**Consultation Response from KC,
Trees**

2025/91870 Land off, Roslyn Avenue, Netherton, Huddersfield, HD4 7EW

Variation of conditions 5 (plans), 29 (ecological design strategy), 32 (site access works and road marking improvements), 33 (internal estate streets scheme), 34 (play area), 37 (information boards), 39 (vehicle parking areas surface and drainage) and 41 (bin storage area and waste collection point) of previous permission 2023/93503 for outline application for residential development of 82 dwellings and associated works, with layout and access as considerations

Date Responded: 08/08/2025

External Levels Plan

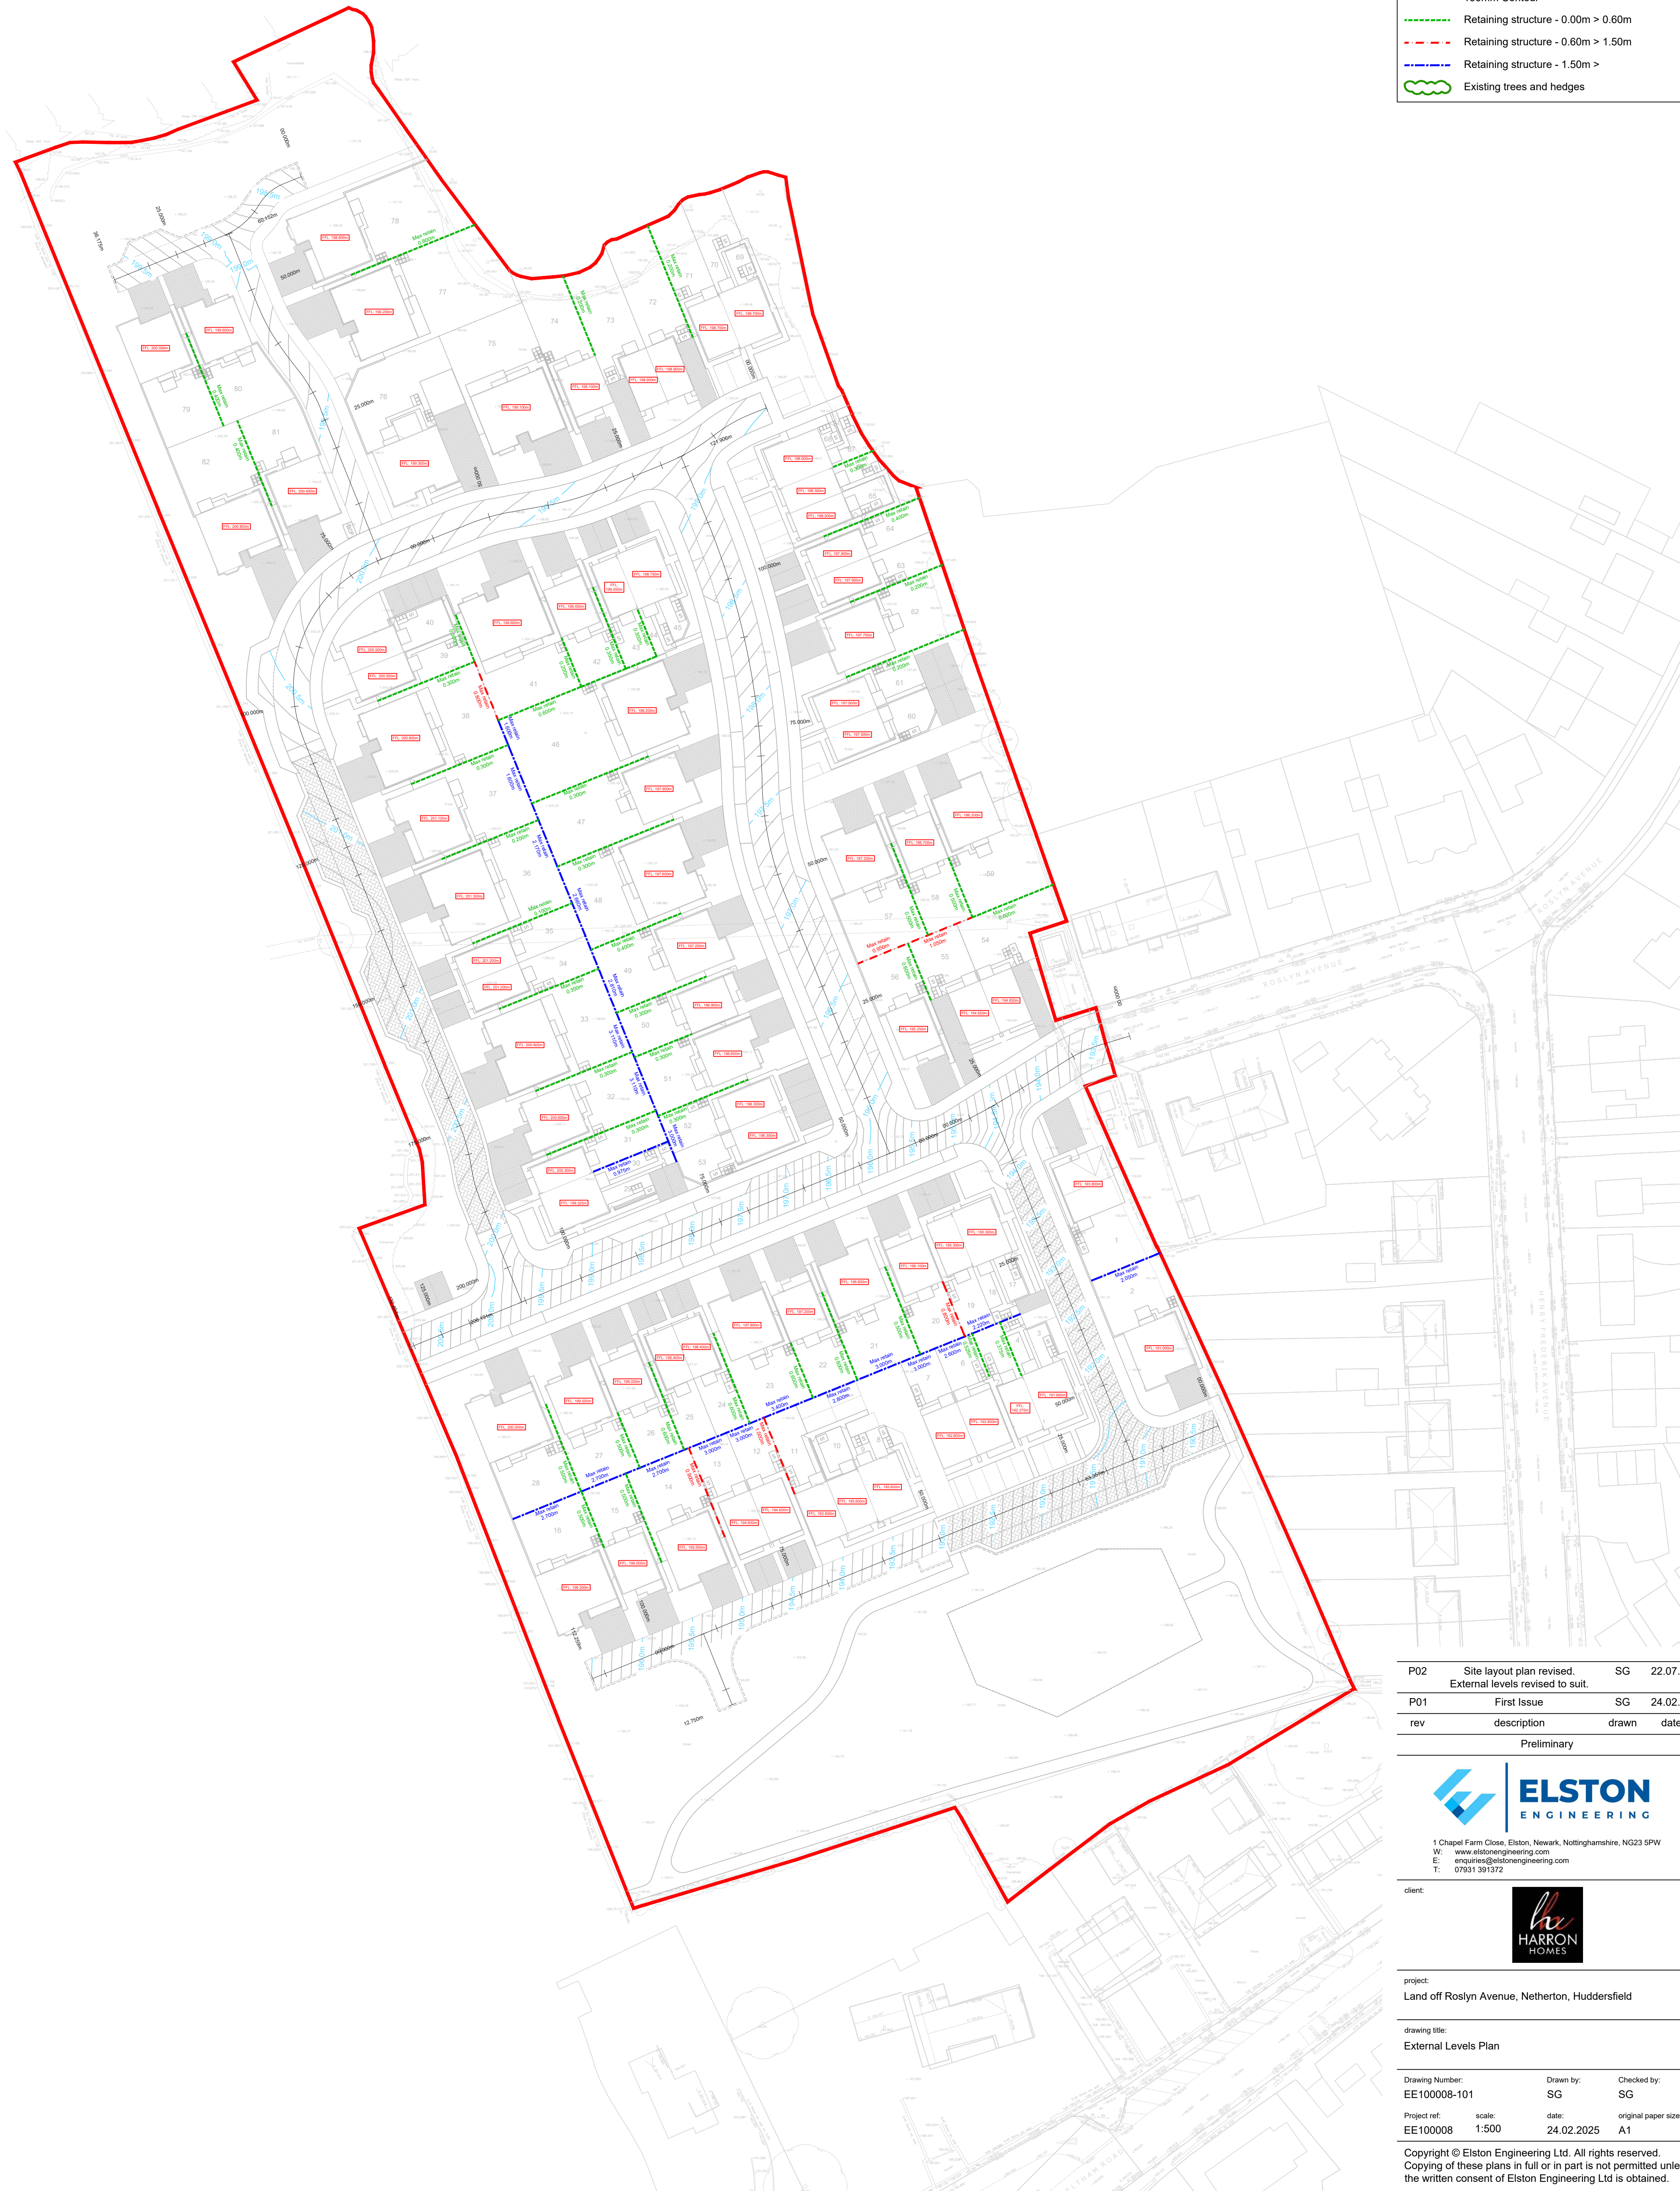
To the north of the site there is an area of ancient woodland which is also protected by TPO HU1/49/w10. The new plans show that the development may now impact on these protected trees by being moved north into the buffer zone.

A new Arboricultural Impact Assessment (AIA) and Arboricultural method statement (AMS) needs to be submitted to definitively show whether the ancient woodland has or hasn't been given a minimum of 15 meter buffer zone and how this will be enforced during construction.

With regards to the unprotected trees to the east, south and west of the site. Again, any change to the plans requires an updated AIA and AMS to reflect the new impact on the trees and what protection they may require during construction.
